Rezoning Petition Review

Date of Review: January 7, 2008 **(Revised April 7, 2008)**

Rezoning Petition #: 08-40

Location of Property: Approximately 36.60 acres located on the northeast quadrant of the Johnston Road and I-485 Interchange

REGISTRATION COPYRIGHT ©
 SHEET TITLE
 2007 REZONING NOTES
 SHEET NUMBER

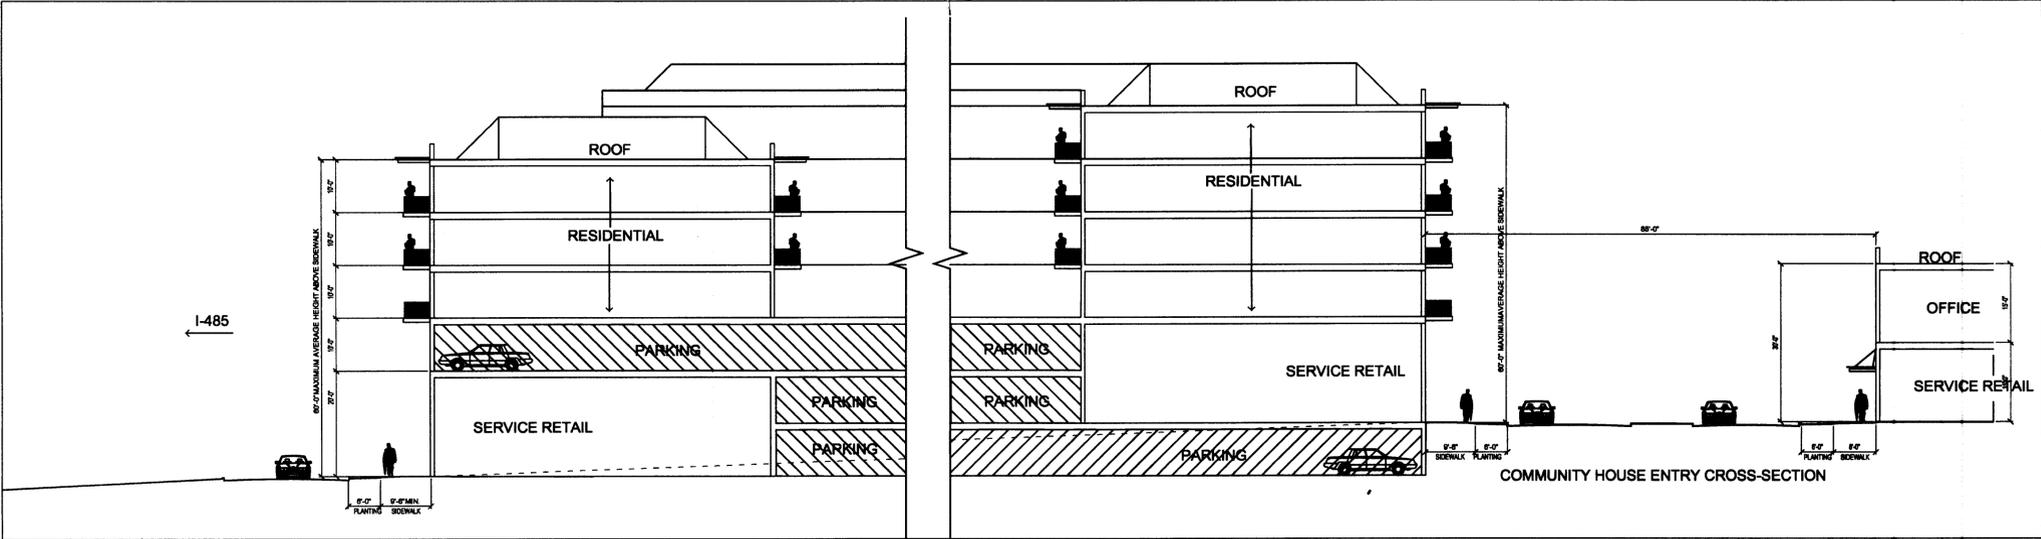
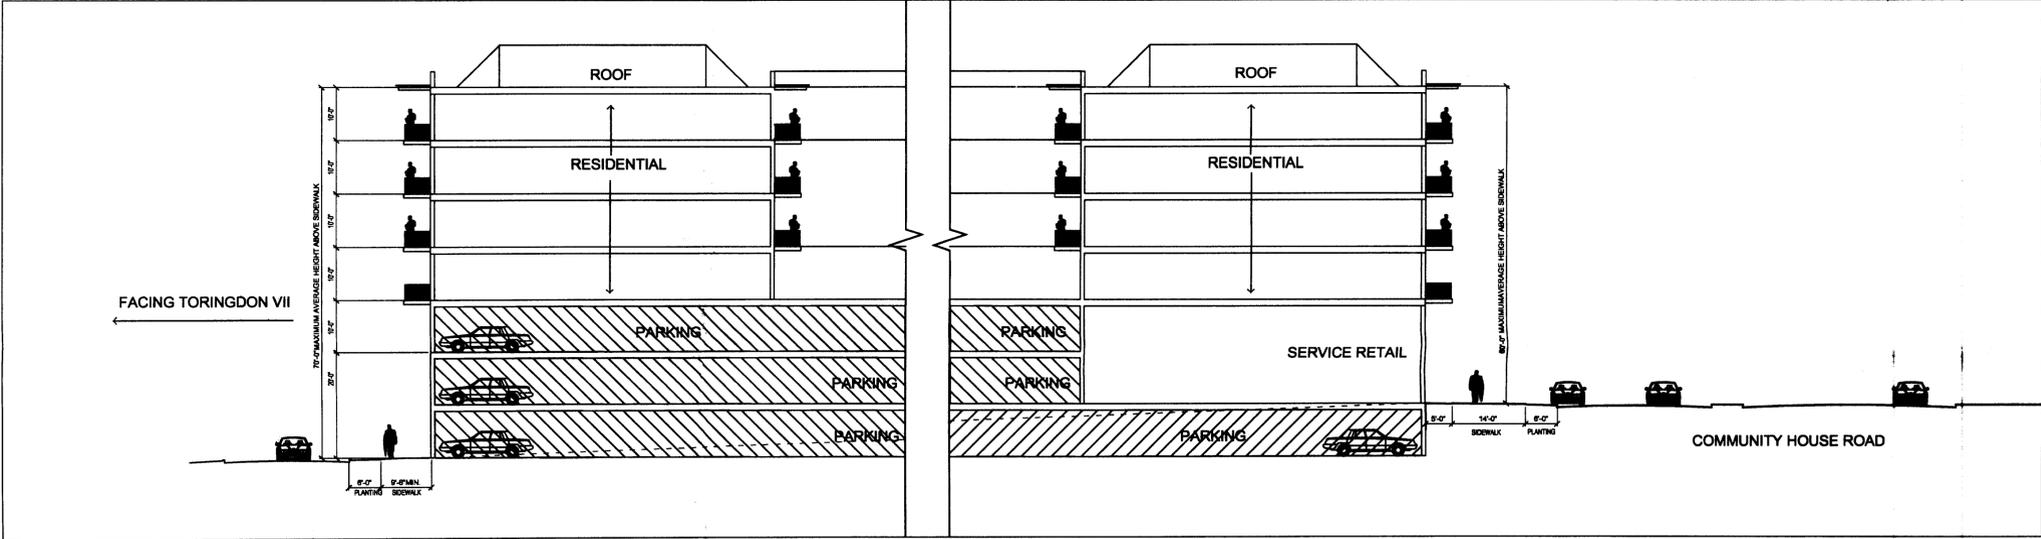
Remove Note 14 under General Notes.

Remove Note 5 under Rezoning Notes.
